A SUBDIVISION OF A PORTION OF THE SOUTH 1/2 OF SECTION 27, RANGE 67 WEST OF THE SIXTH PRINCIPAL
MERIDIAN, COUNTY OF EL PASO, STATE OF COLORADO

THIS PLAT FOR "LEWIS-PALMER SCHOOL DISTRICT No. 38 FILING NO. 1" SUBDIVISION WAS APPROVED FOR FILING BY THE EL PASO COUNTY, COLORADO PLANNING AND COMMUNITY DEVELOPMENT DEPARTMENT DIRECTOR ON THE _____ DAY OF _____, 2022, SUBJECT TO ANY NOTES OR CONDITIONS SPECIFIED HEREON.

AUGUST 31, 2022

# LEWIS-PALMER SCHOOL DISTRICT No. 38 FILING NO. 1

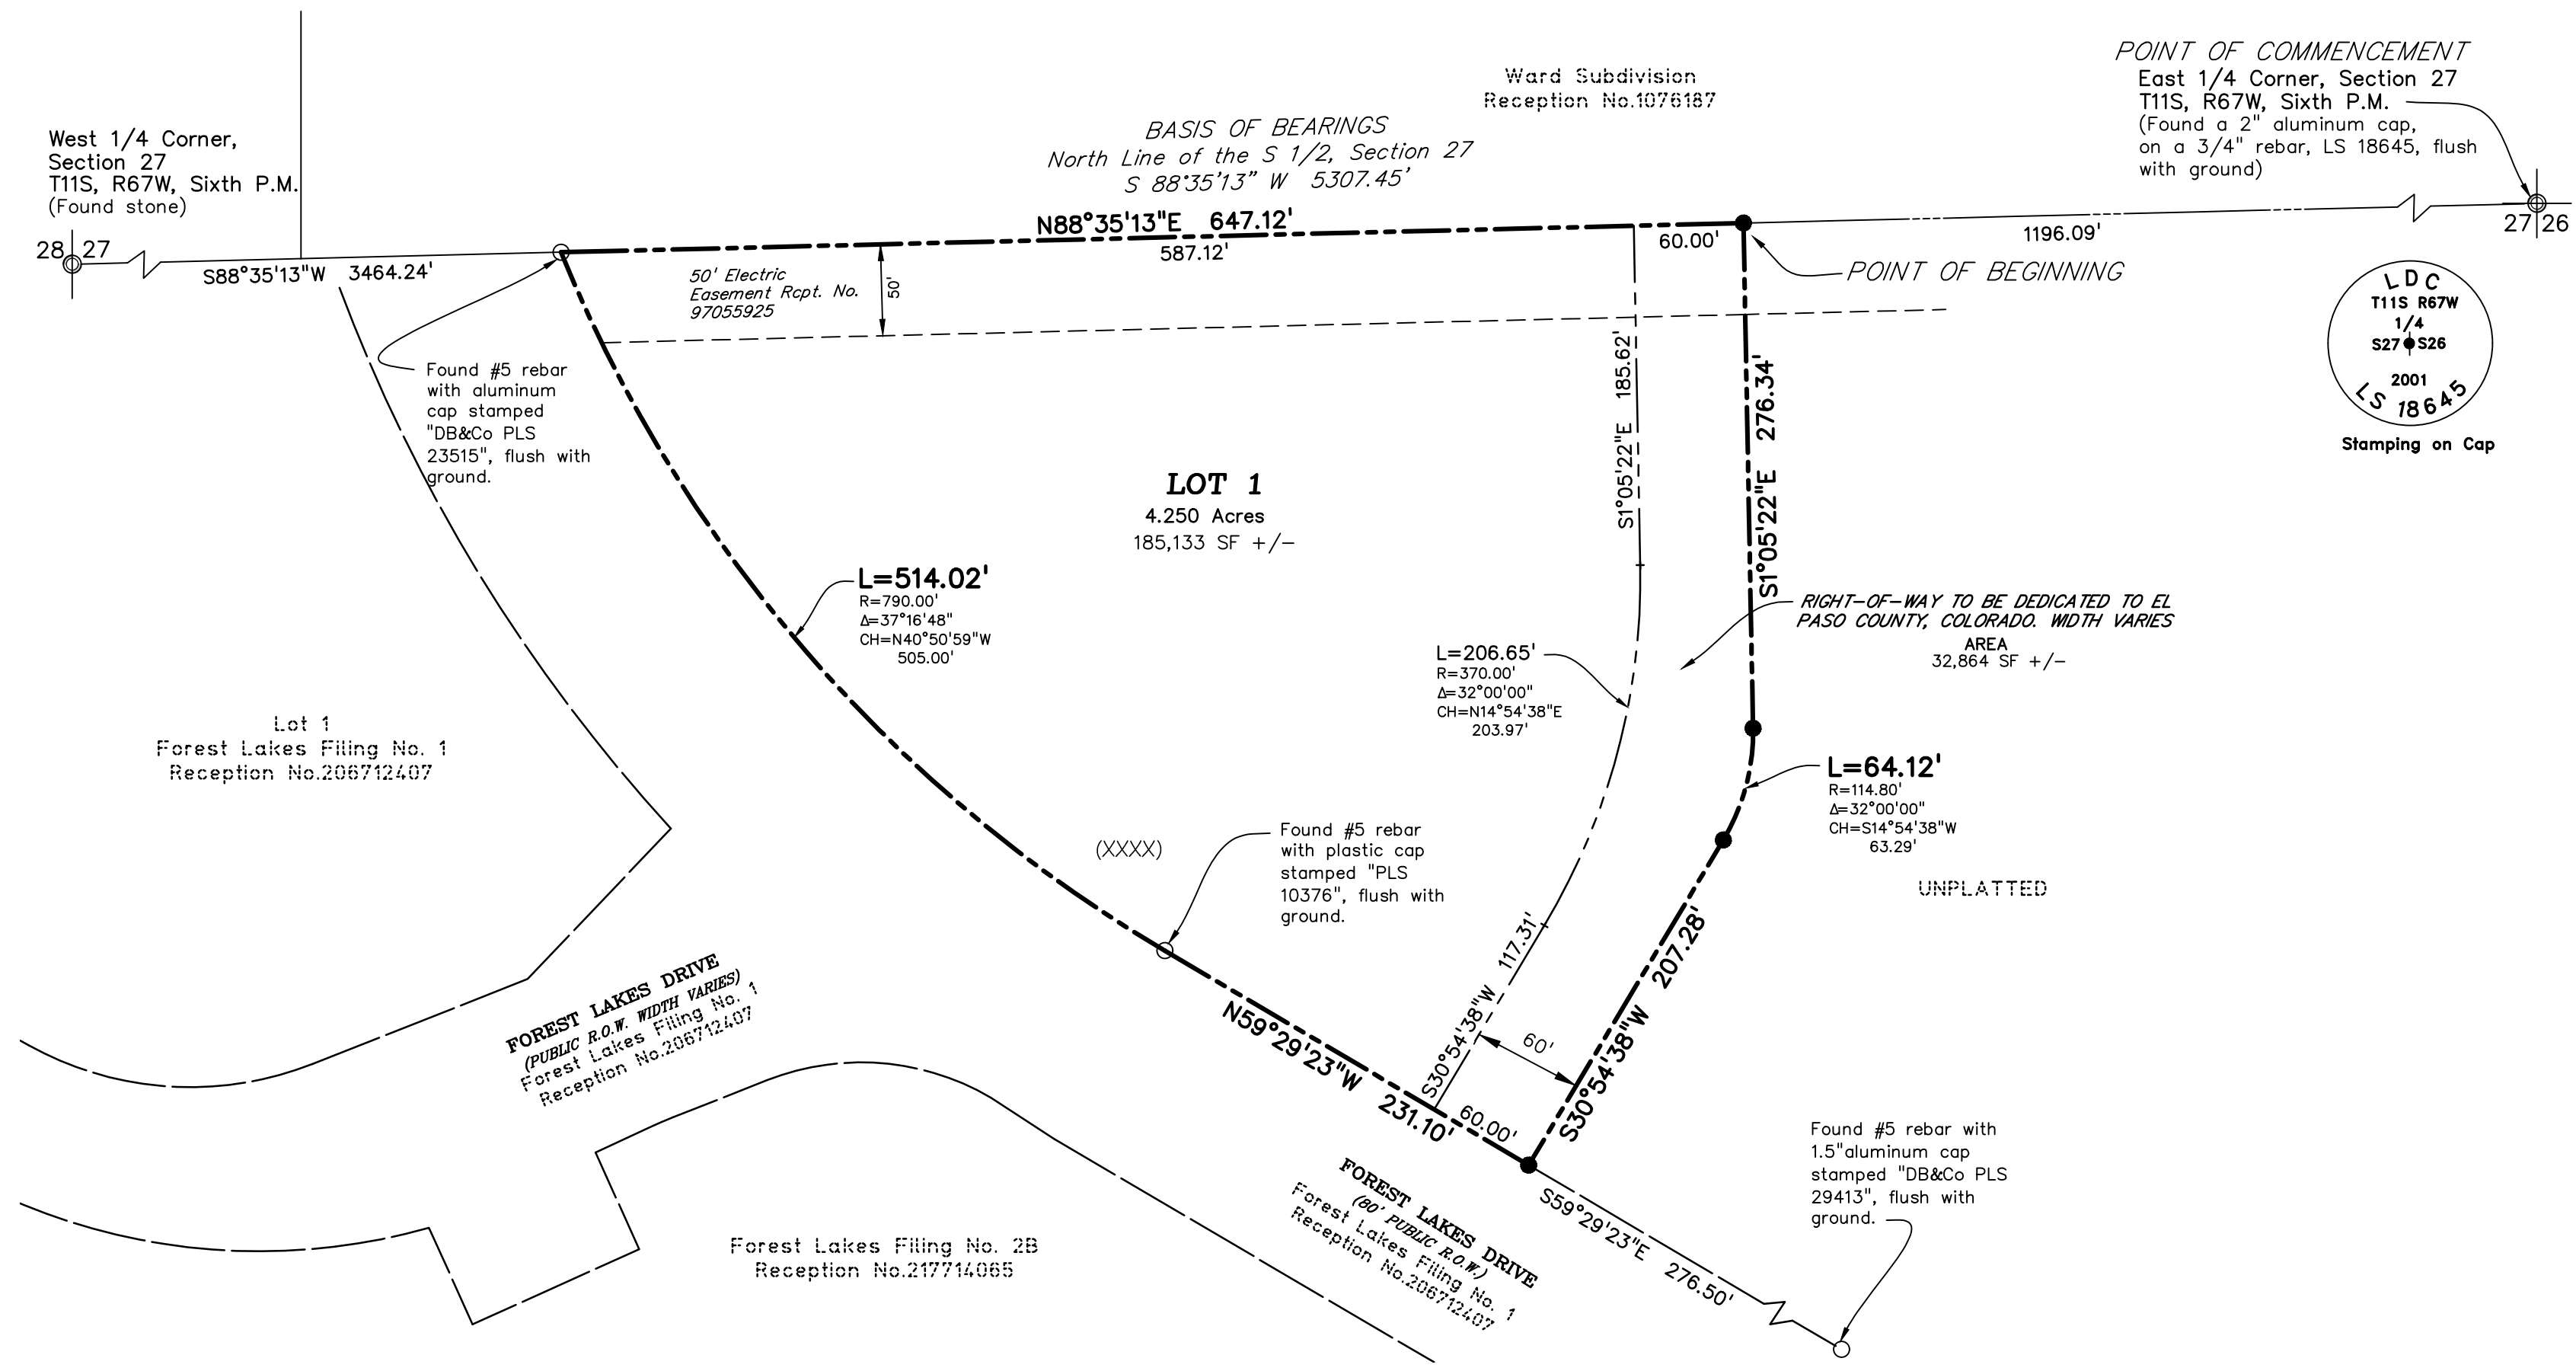
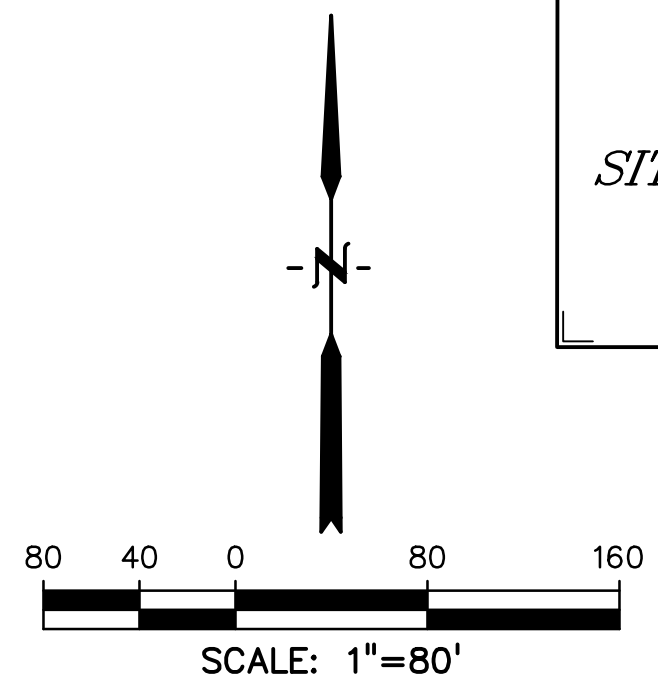
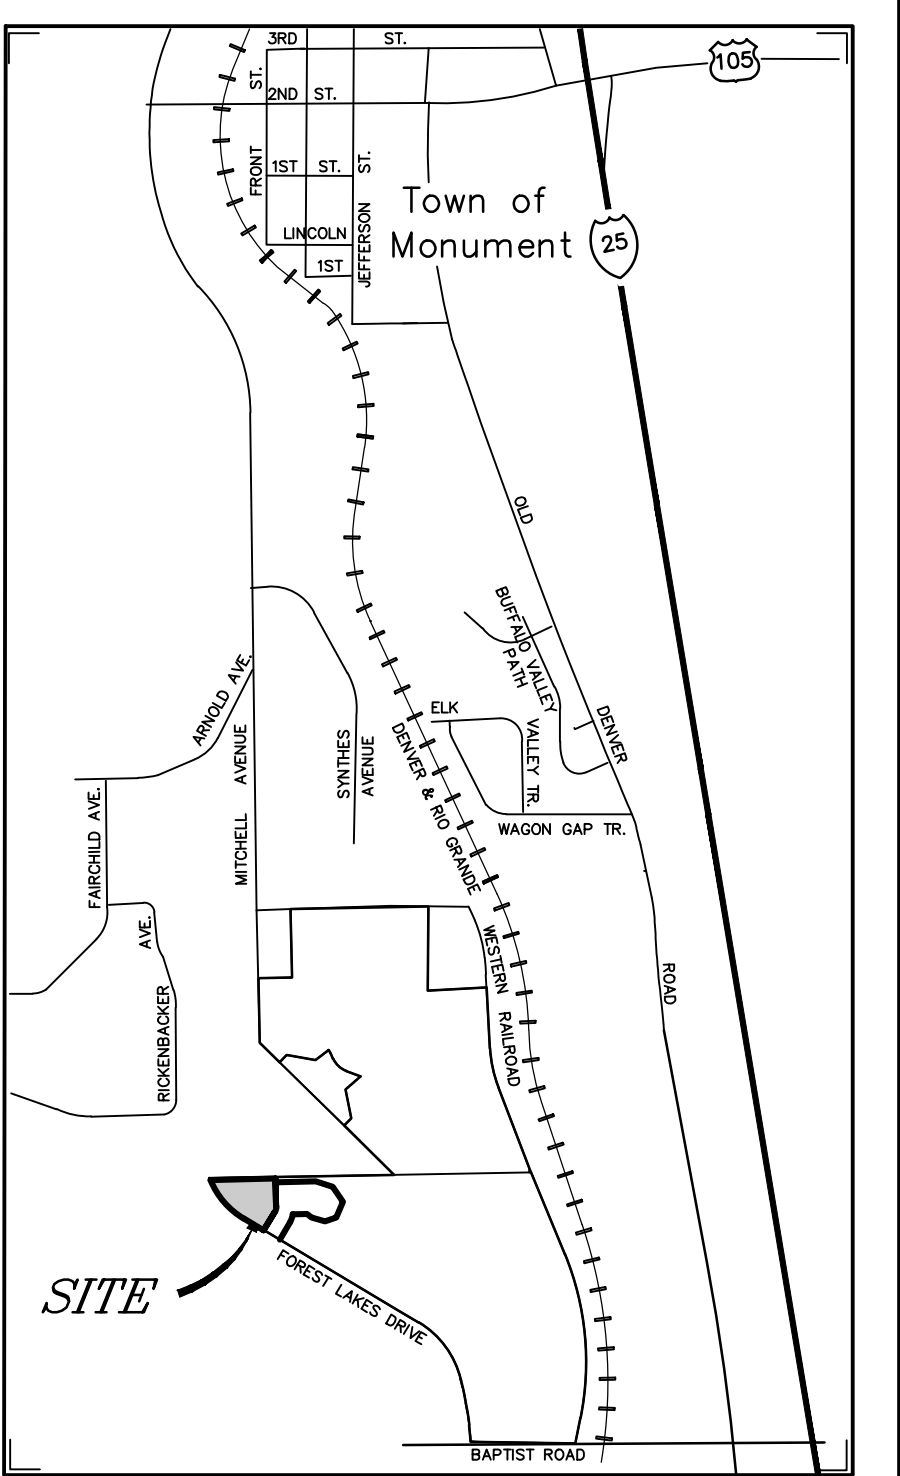
**Add Plat Note-
Easements:**
Unless otherwise indicated, all side, front, and rear lot lines are hereby platted on either side with a 10 foot (use 5 feet for lots smaller than 2.5 acres) public utility and drainage easement unless otherwise indicated. All exterior subdivision boundaries are hereby platted with a 20 foot (use 7 feet for lots smaller than 2.5 acres) public utility and drainage easement. The sole responsibility for maintenance of these easements is hereby vested with the individual property owners.

Add Plat Note-
Access:
No driveway shall be established unless an
access permit has been granted by El
Paso County.

- The final total gross acreage, gross density, net density and net acreage of the subdivision
- The net acreage of land to be dedicated
